TOWN OF MONUMENT - WATERLINE AND STORAGE TANK
 SITE DEVELOPMENT PLANS
 LOT 6, FOREST VIEW ESTATES FILING NO. 4

2.0 MG WATER STORAGE TANK

90% SUBMITTAL

TANK PROFILE
SCALE: 1" = 10'

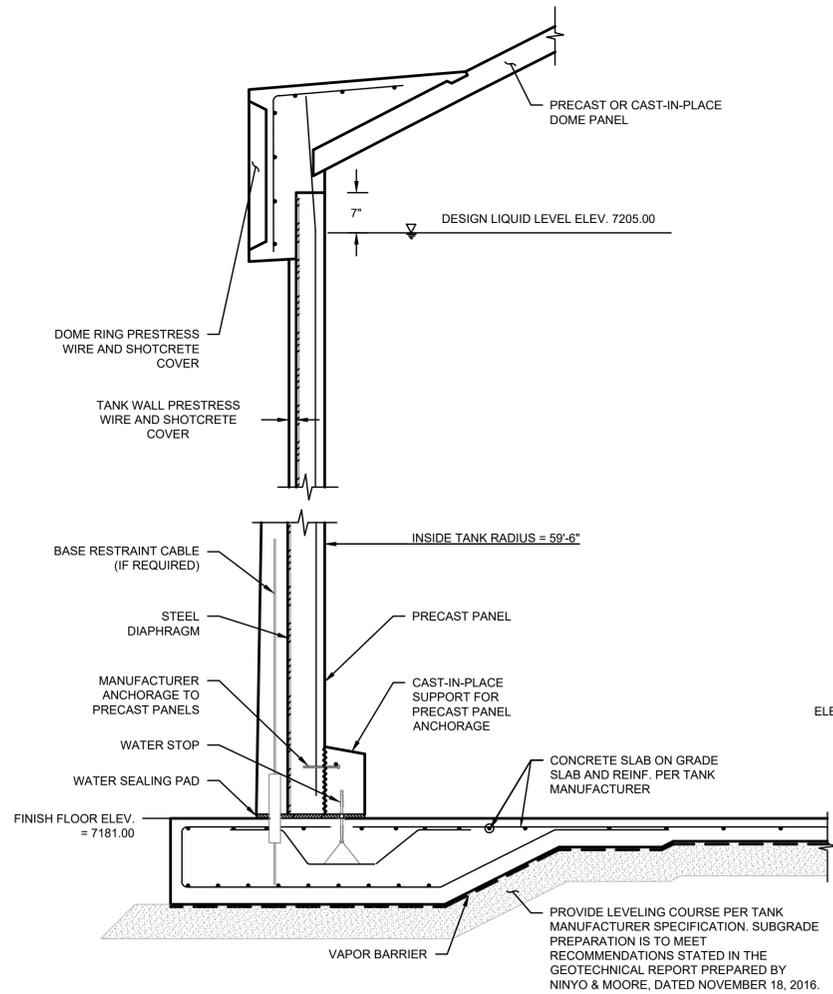
Add circumference and total gallon storage

LIGHT POLE FOUNDATION DETAIL

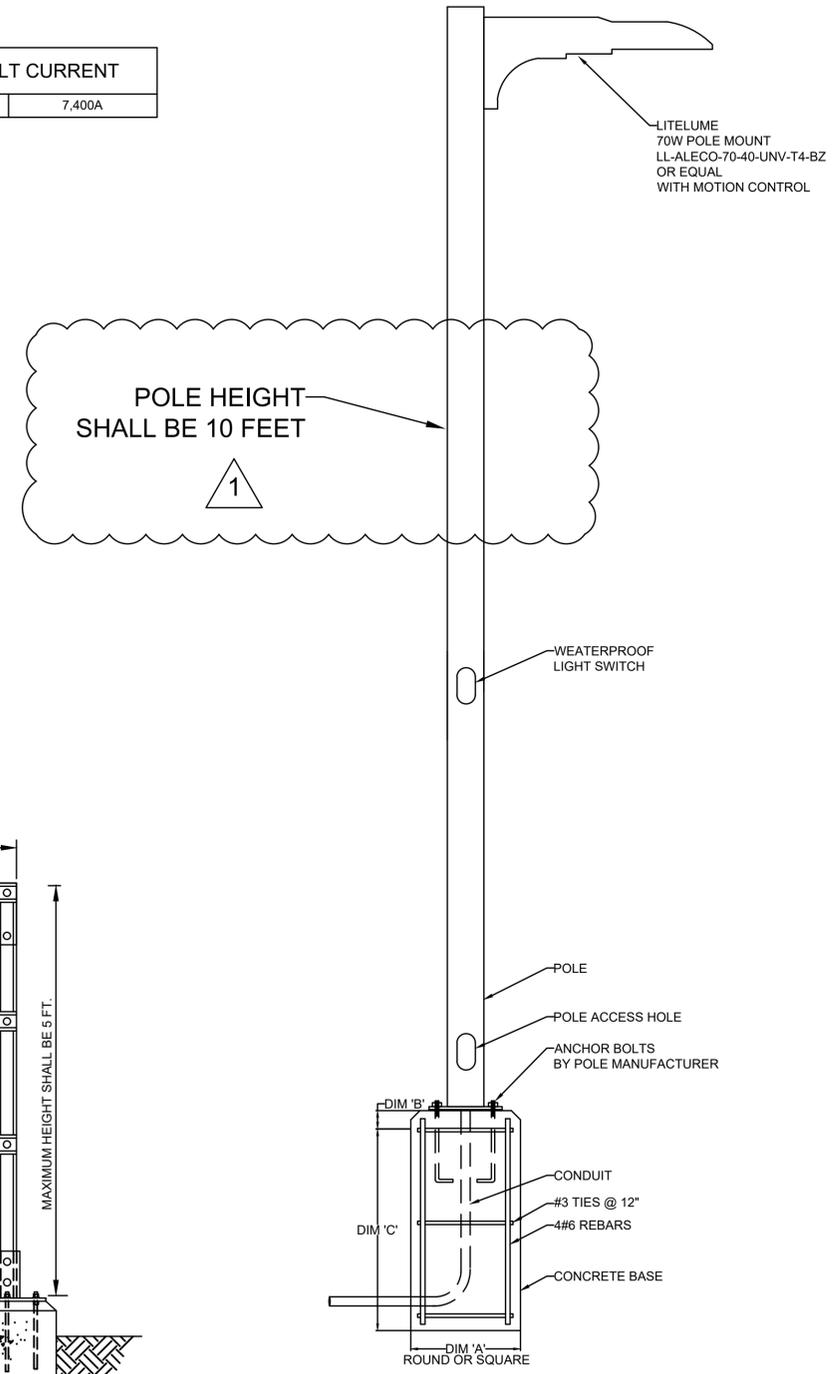
Add note that lumens will not exceed Max (based on Code)

This exceeds the lighting standards; revise per Code above (Chapter 6). Please provide the exact detail for the fixture and pole- This is very industrial in nature; this is a residential zone district;

TANK SITE PLAN
SCALE: 1"= 20'

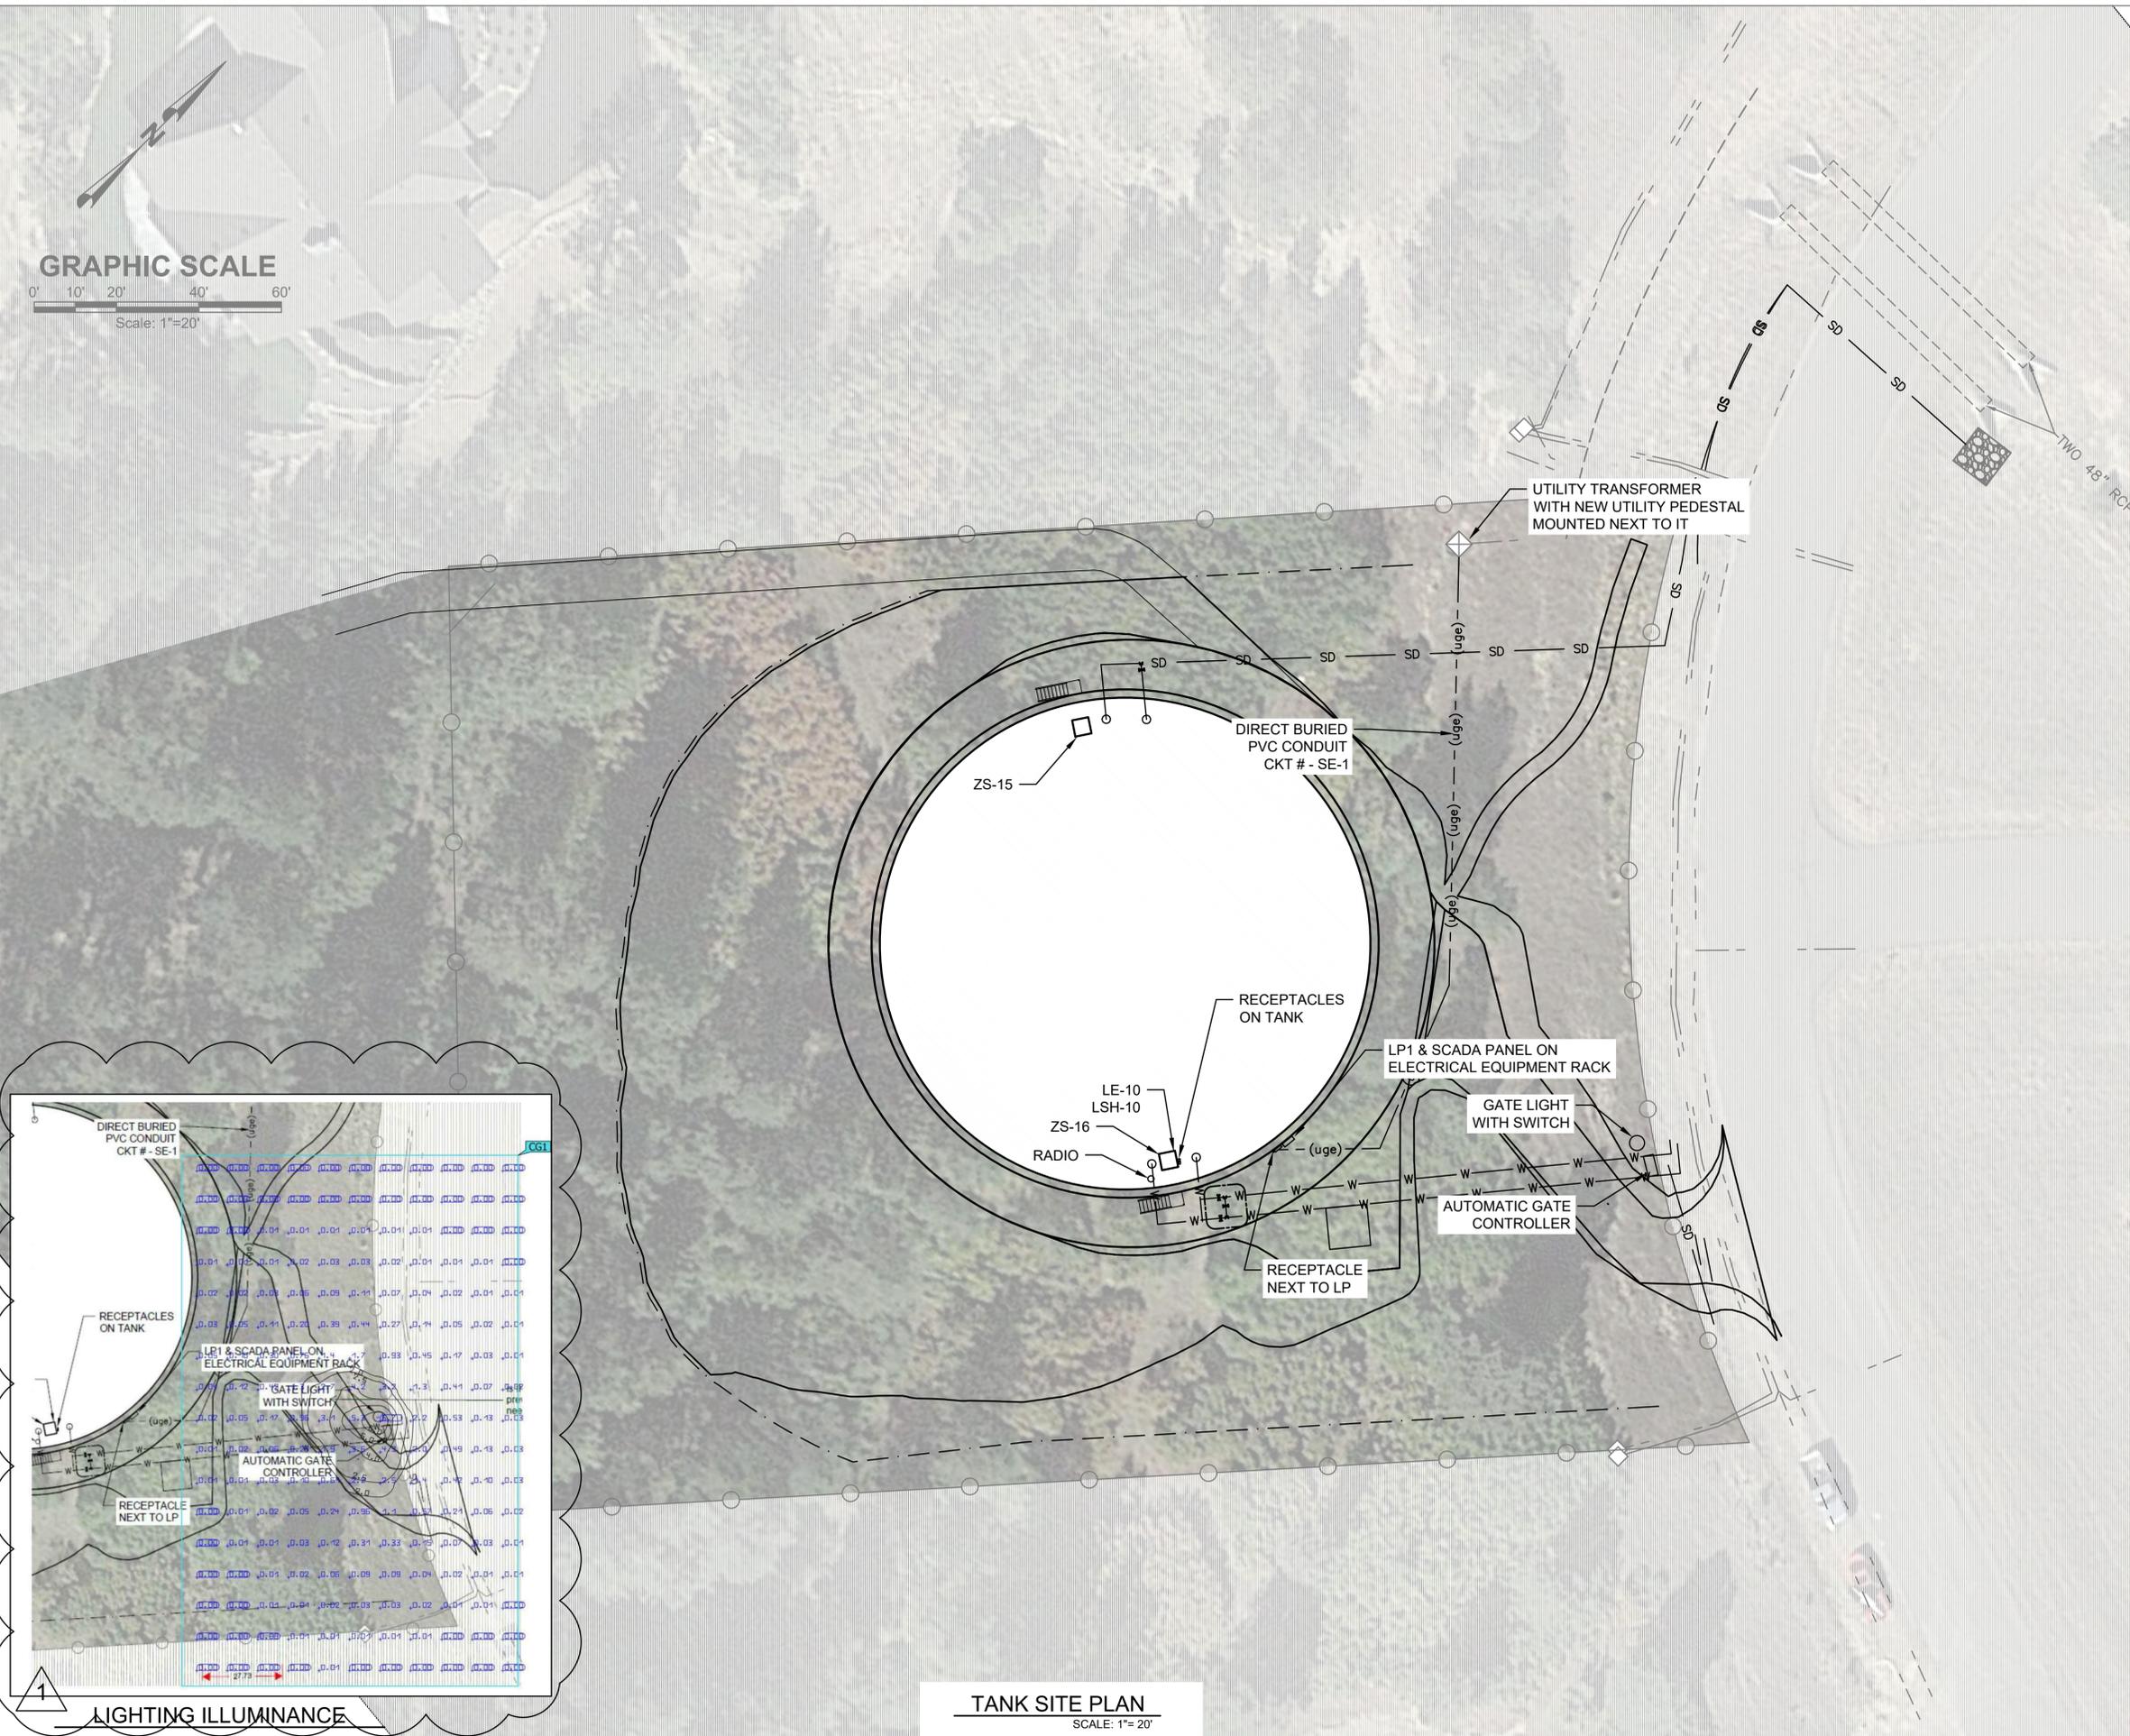
locate light fixtures on this sheet as well as sheet 2

Provide the detail of the chain link fencing, and the alternative fencing.

is there only one light on entire project? If not add locations and detail of fixture
